From: Andrew Wood <Andrew.Wood@arun.gov.uk>
Sent: 21 October 2019 13:58
To: Robert Steventon [REDACTED]
Cc: Richard Sloman [REDACTED]
Subject: FW: Planning Consultation on A/113/19/DOC - Angmering site

Engineers Comments Regarding Condition 9- surface water drainage design

APPLICATION NO: A/113/19/DOC

Site Address: Crete Nursery Dappers Lane Angmering BN16 4EN

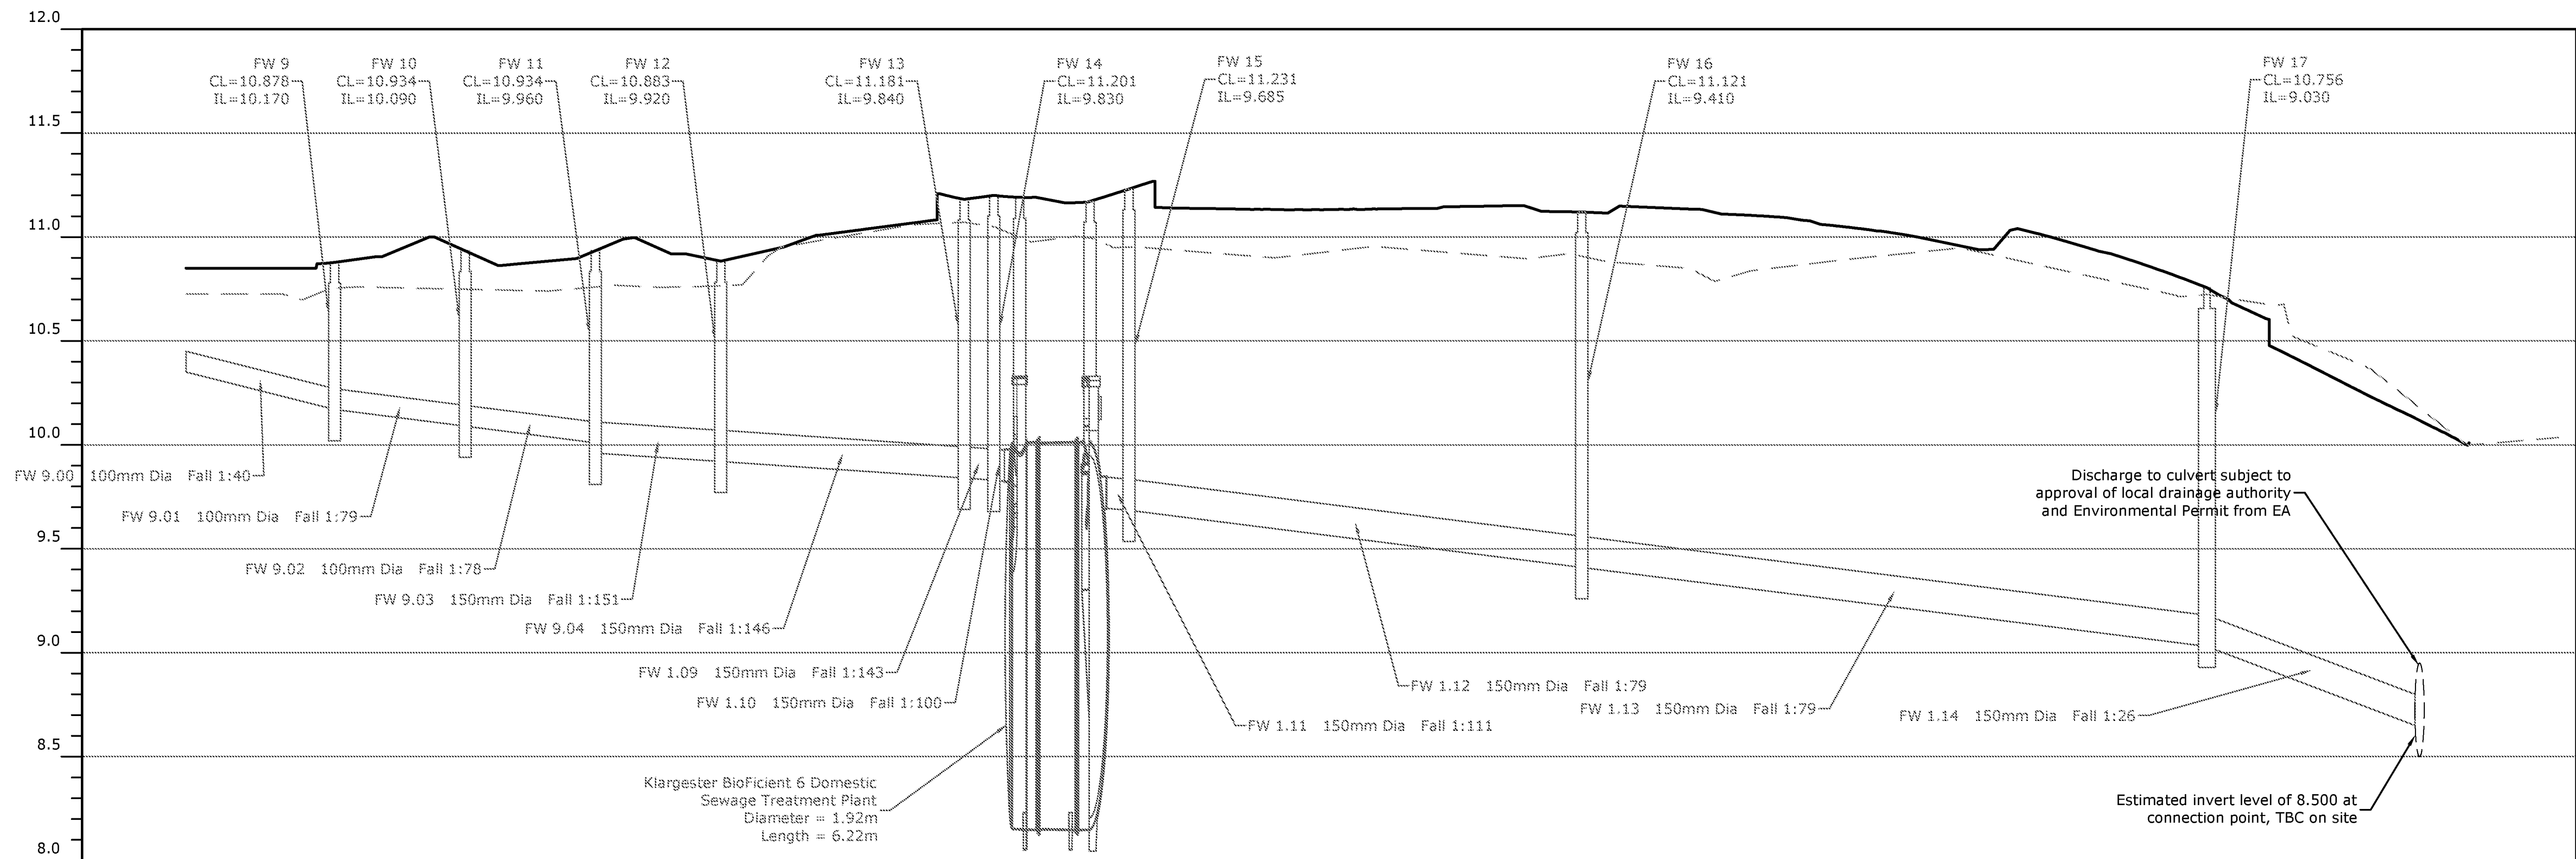
3. Please can an impermeable areas plan be provided that clearly shows the impermeable areas draining to each surface water drainage feature. Please refer to enclosed drawing 191183/SK/04 for impermeable areas. *This will likely need to be revised due to comment 9 below.*
4. The filter drain is inadequate. Maximum modelled water depths are nearly 1m. This clearly will not be able to be contained above maximum recorded groundwater level. The groundwater monitoring found that the highest groundwater level in the vicinity of the filter drain was 1.48m below ground level. This has been shown on the filter drain long section 191183 2 Crete Nursery, Dappers Lane, Angmering, Bn16 4en11

September 2019 drawing 191183/520/02 and therefore the filter drain will be above the maximum groundwater level. As shown on the drawing, Filter Drain 1 is flat, and Filter Drain 2 is sloped, and this is correctly reflected in the MicroDrainage calculations. Location actually appears to be between WS1 and WS2. For clarity, please overlay monitoring locations onto drainage strategy drawing.

5. From looking at cross sections it also appears that the filter drain will be on a slope, please ensure this is accurately depicted within calculations.

3. Please can an impermeable areas plan be provided that clearly shows the impermeable areas draining to each surface water drainage feature.
4. The filter drain is inadequate. Maximum modelled water depths are nearly 1m. This clearly will not be able to be contained above maximum recorded groundwater level.

5. From looking at cross sections it also appears that the filter drain will be on a slope, please ensure this is accurately depicted within calculations.
